KITTITAS COUNTY COMMUNITY DEVELOPMENT SERVICES

Martens Enterprises, LLC
PO Box 458
Cle Elum, WA 98922
RE: Incomplete Application

Kittitas County Community Development Services accepted your application for the proposed Marion Meadows Estates PUD on December 22, 2016. The application materials submitted were for a Planned Unit Development Rezone (PUD), a Long Plat Application, an Administrative Conditional Use Permit (CUP) application, and a Development Agreement (D.A.).

Letter of Incomplete Application –Applicants Response

MARIAN MEADOWS ESTATES PUD PRELIMINARY PLAT
 A PORTION OF SECTION 1 & A PORTION OF SECTION 12, T. 20 N., R. 13 E., W.M.,
 KITTITAS COUNTY, WASHINGTON

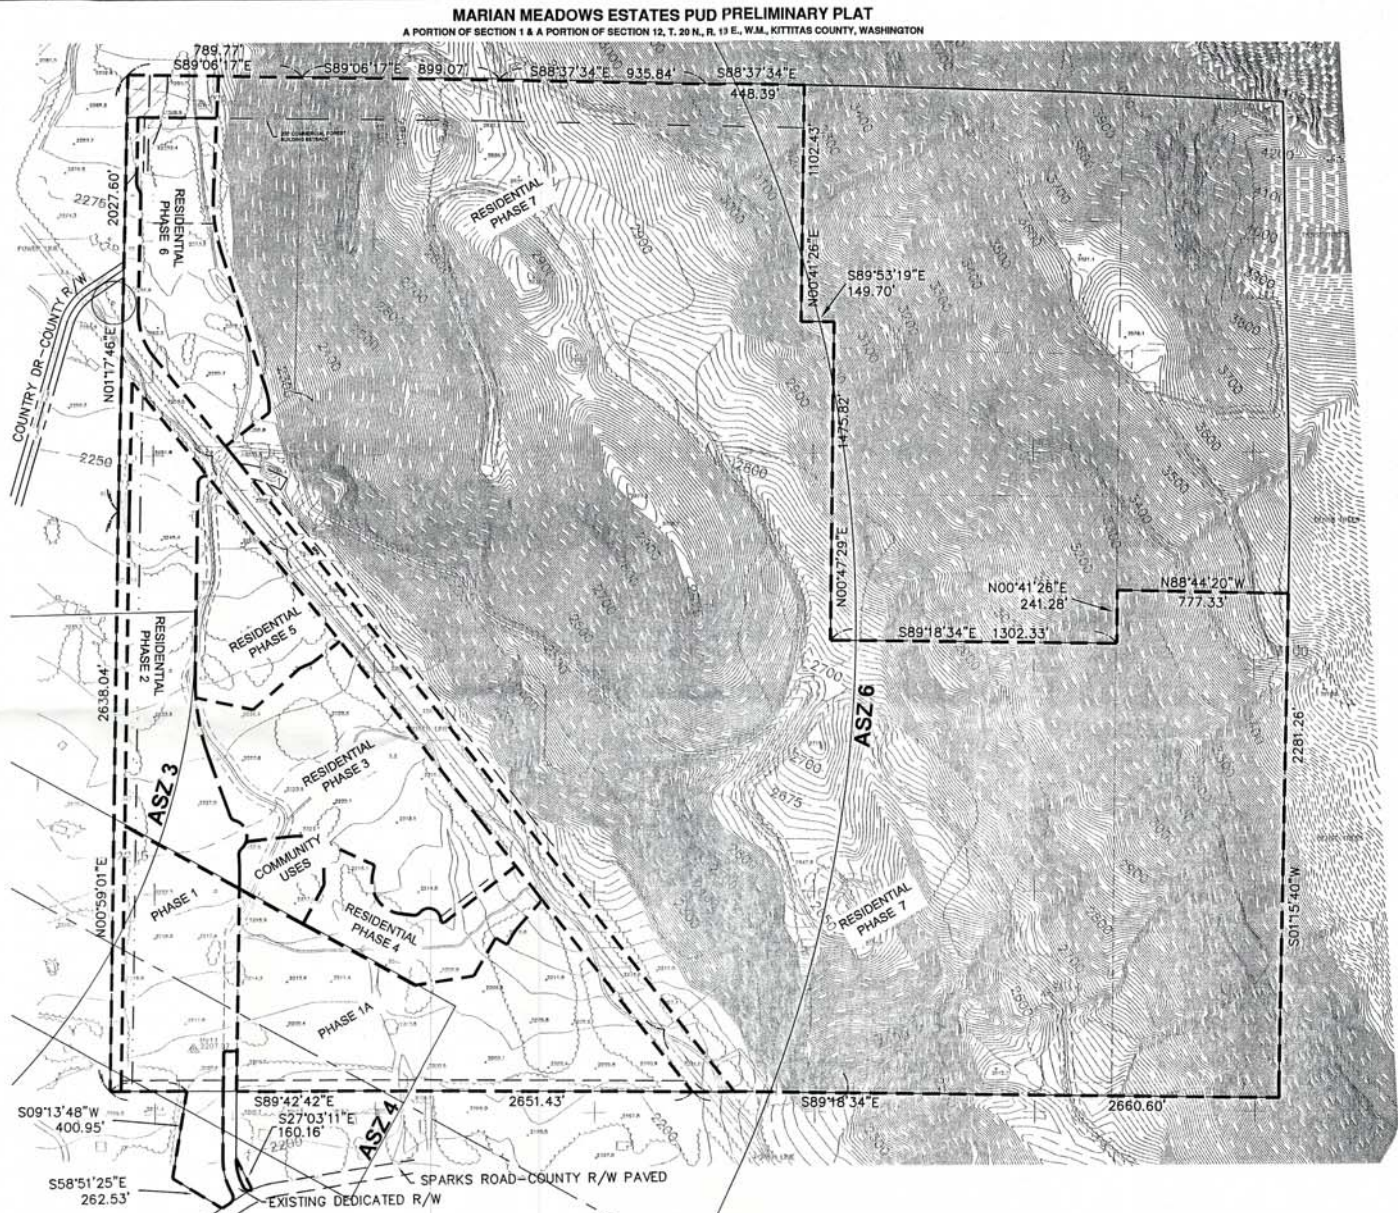
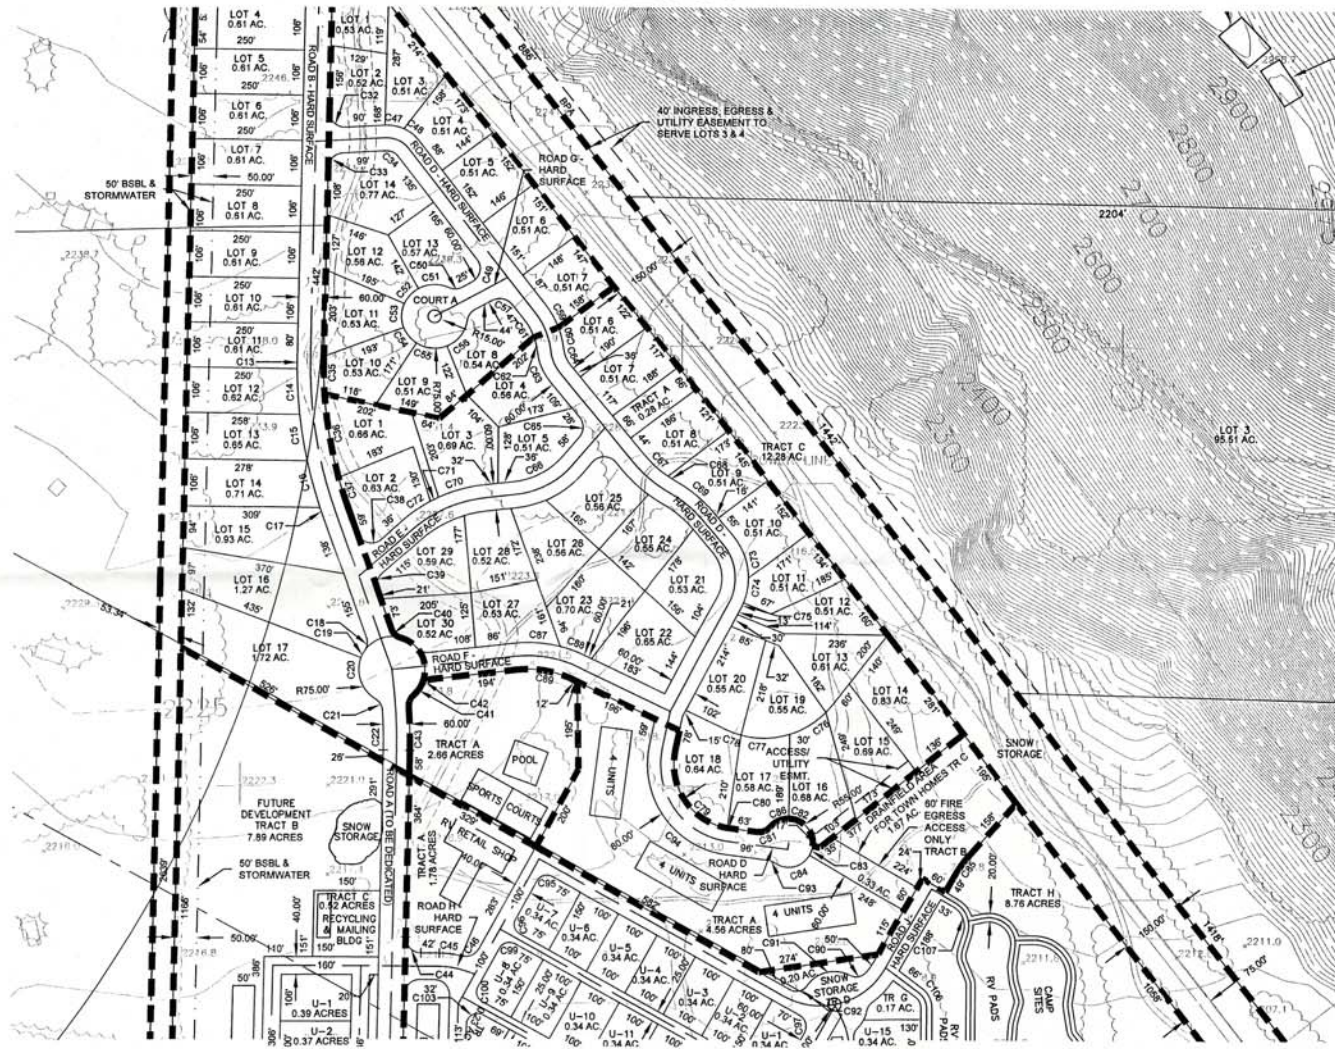
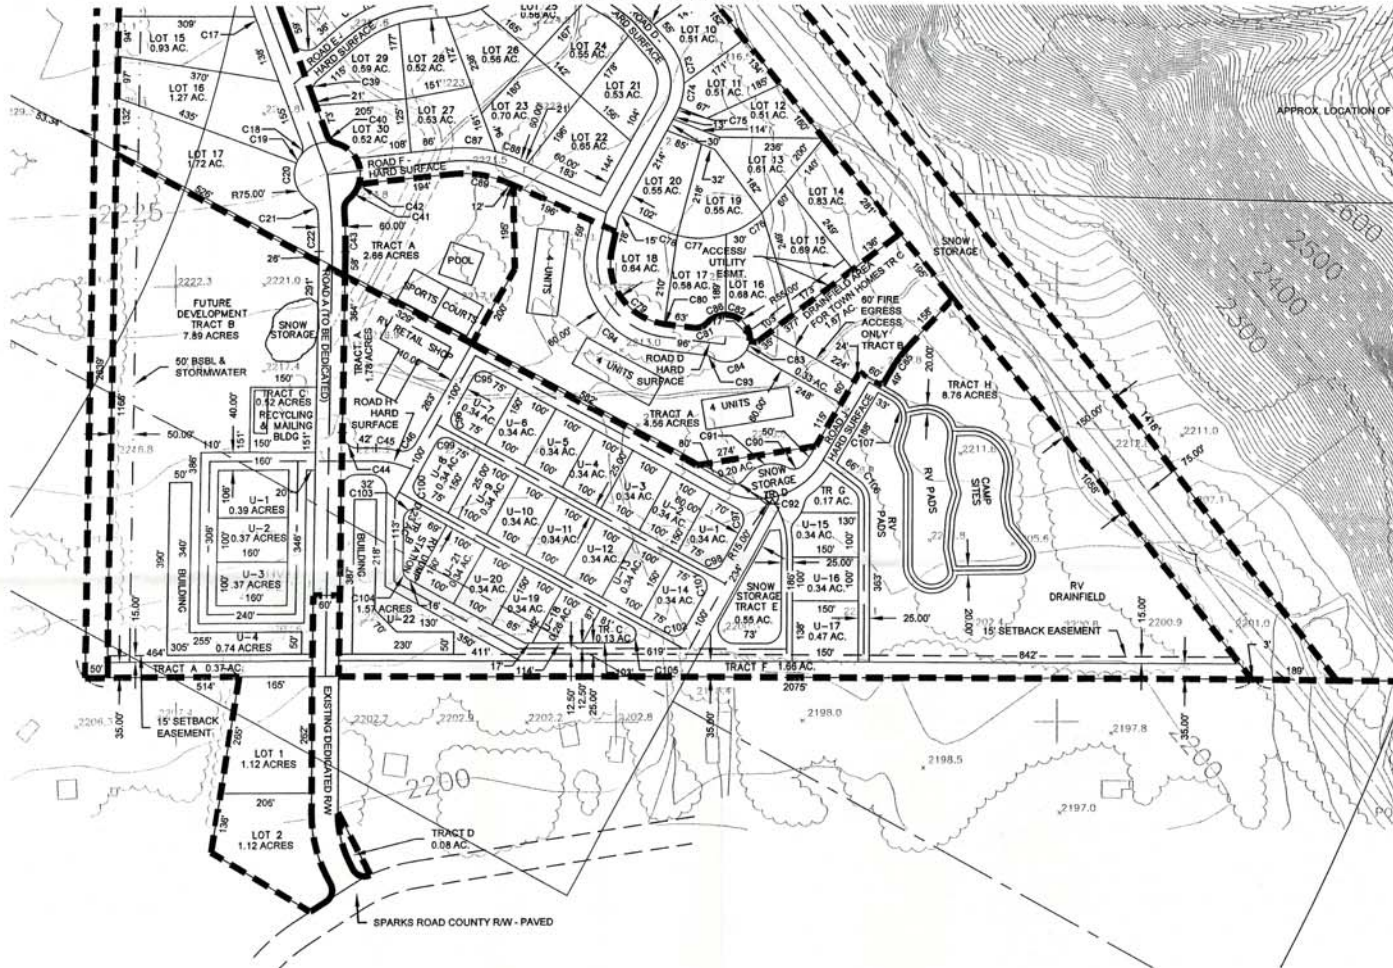
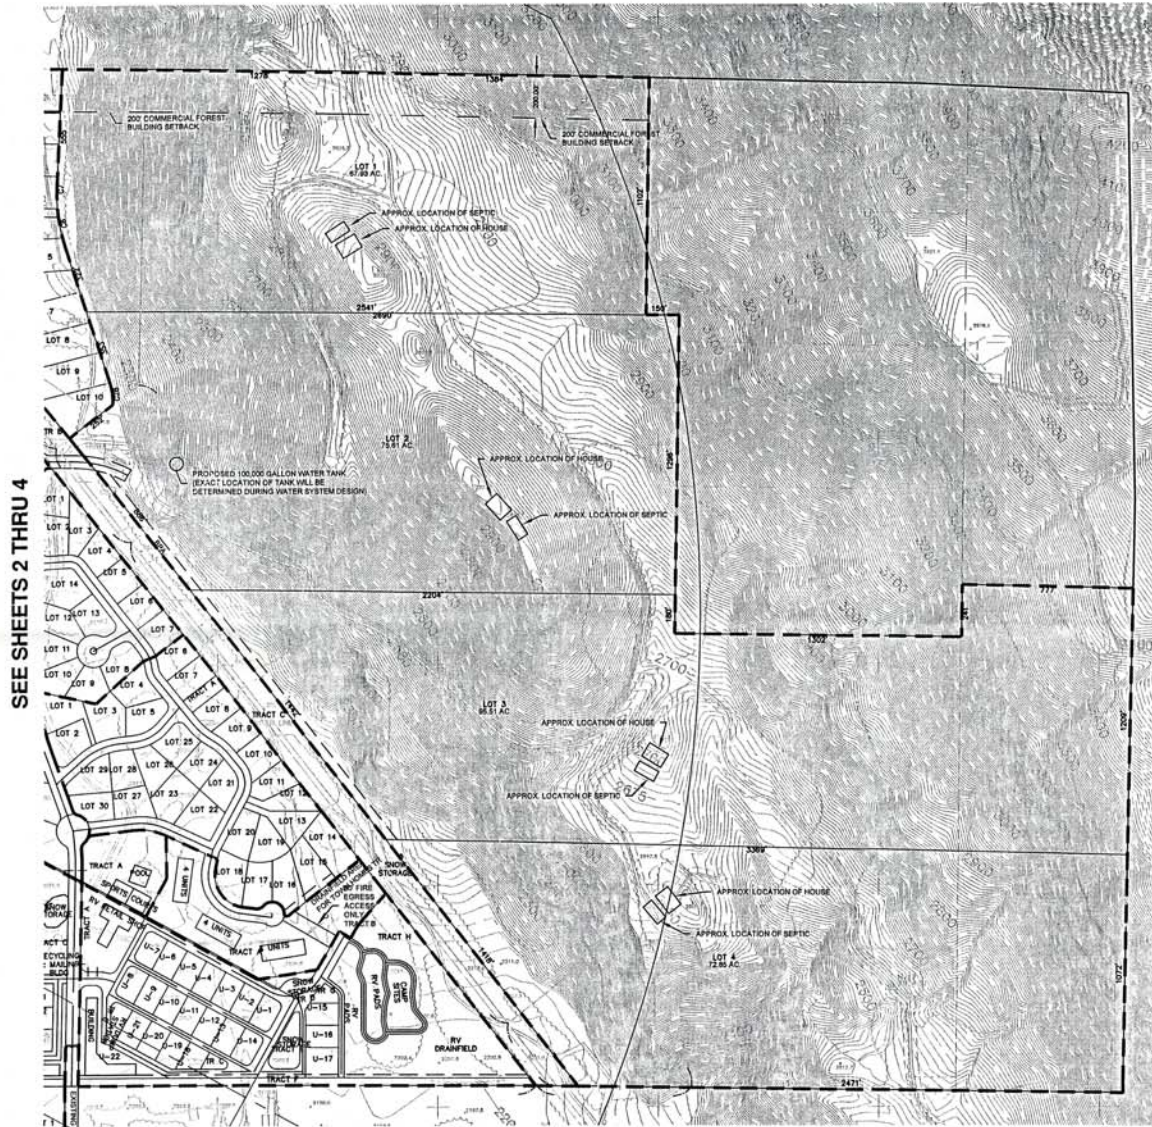
- c) Lot dimensions should be shown on the preliminary plat map per KCC 16.12.020(8). See Encompass Engr.
 - d) Prepare a separate plan sheet to address overall open space, trails, and passive and active recreation spaces, including perimeter buffers, and provide notes identifying ownership and maintenance responsibility for each tract per KCC 16.12.060(1). See Exh. MM#2 and Encompass Engr. drawings. Development Agreement should have added note that open space and community tracts will be commonly owned and managed within the HOA.

- f) Include utility easements (min. 10 ft.) on each proposed lot per KCC 16.12.110. See Encompass Engr.
- g) Clearly identify primary access, secondary access, and emergency vehicle only (EVO) access. See Exh. MM#2
